# HKTA / architects

September 5, 2013

About: 133 York Street – Site Plan Review Update

This memo follows up on the design review comments offered by Jean Fraser on August 22 and Barbara Barhydt's emailed comments on August 30 concerning the above project.

1
A-202
NORTH ELEVATION
SCALE: 1/4"=1'-0"

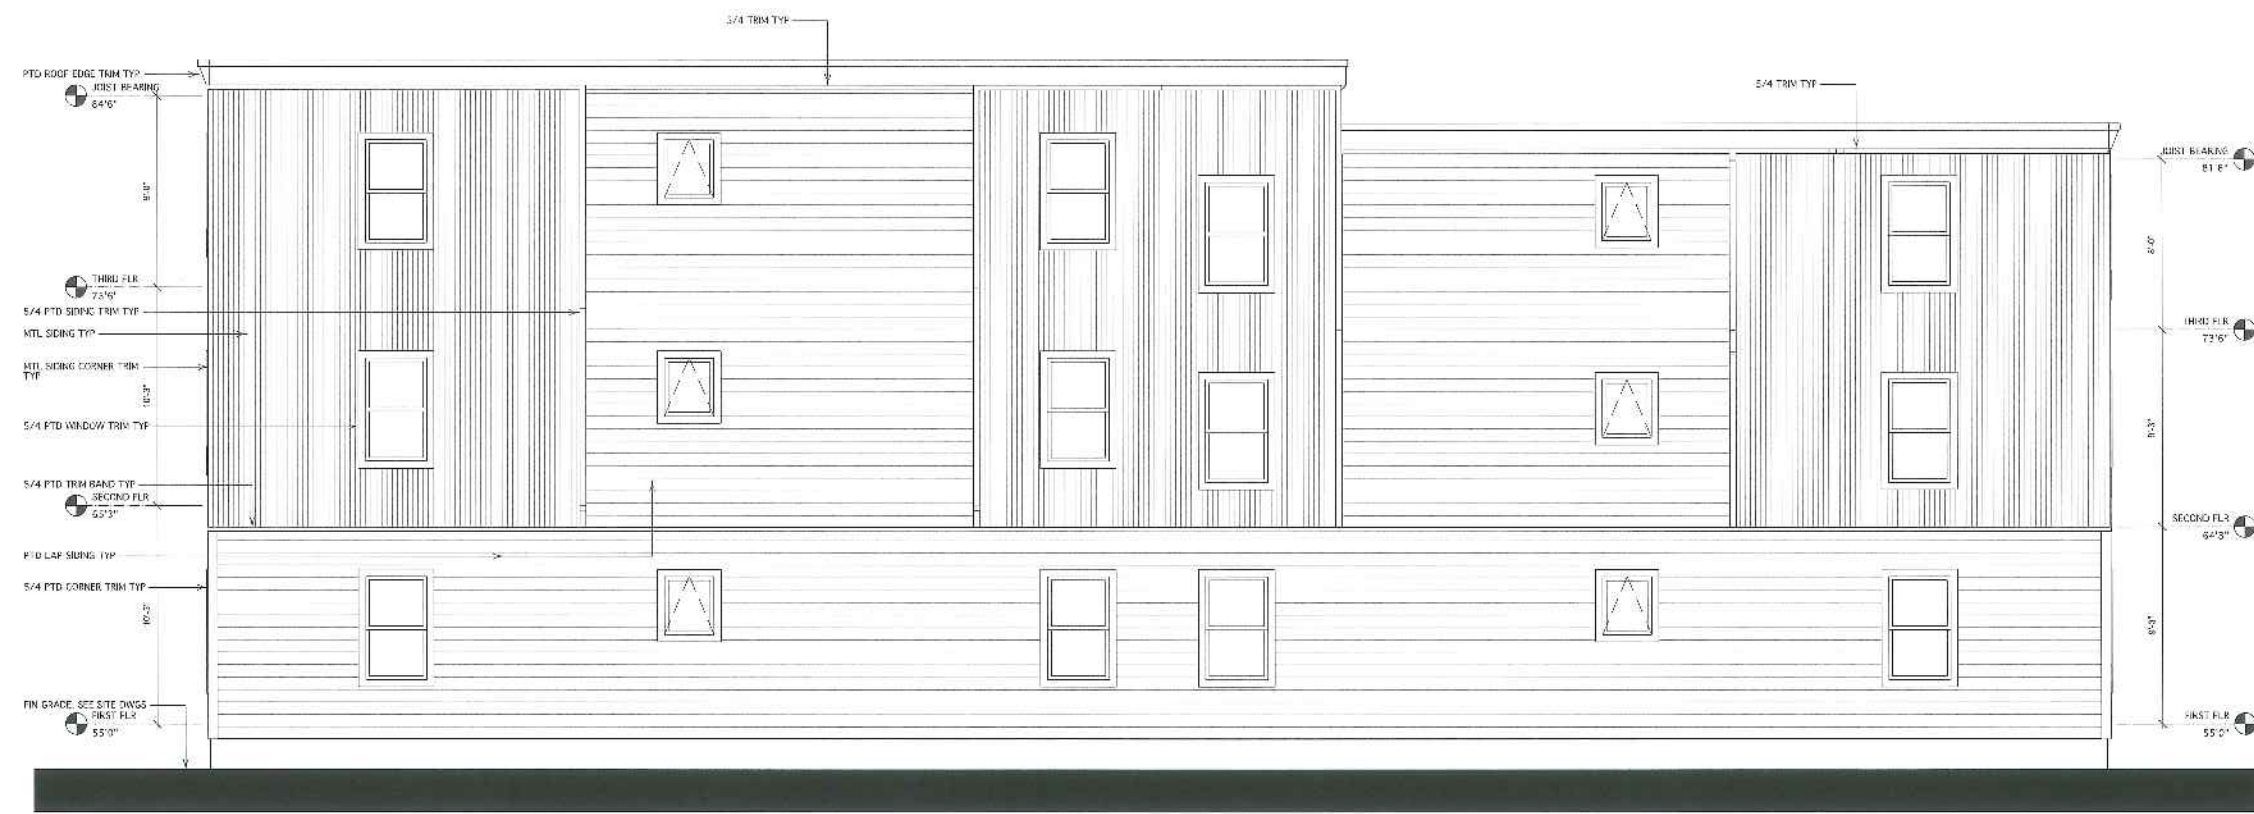
2. The height difference in the two halves reflect what we believed were direction given by city staff in review of zoning requirements and in the belief the height more accurately responded to the height of the existing building. It was determined with review that it was more advantageous to keep that portion lower so it conforms more closely to the expansion possibilities of the existing structure.

3. For clarification about the building height above grade, we offer the following table. These dimensions are drawn directly from the completed construction drawings.

West End	East End
South Elevation (Front)	38' - 2 1/2"	41' - 2 1/2"
North Elevation (Back)	30' - 4 1/4"	33' - 4 1/4"
Grade at Sides	34' - 9 3/4"	37' - 9 3/4"
Existing (Front)	31' - 1"	
Existing (Back)	23 - 6"	
Difference in height between existing and new at West End	6' - 8 1/2"
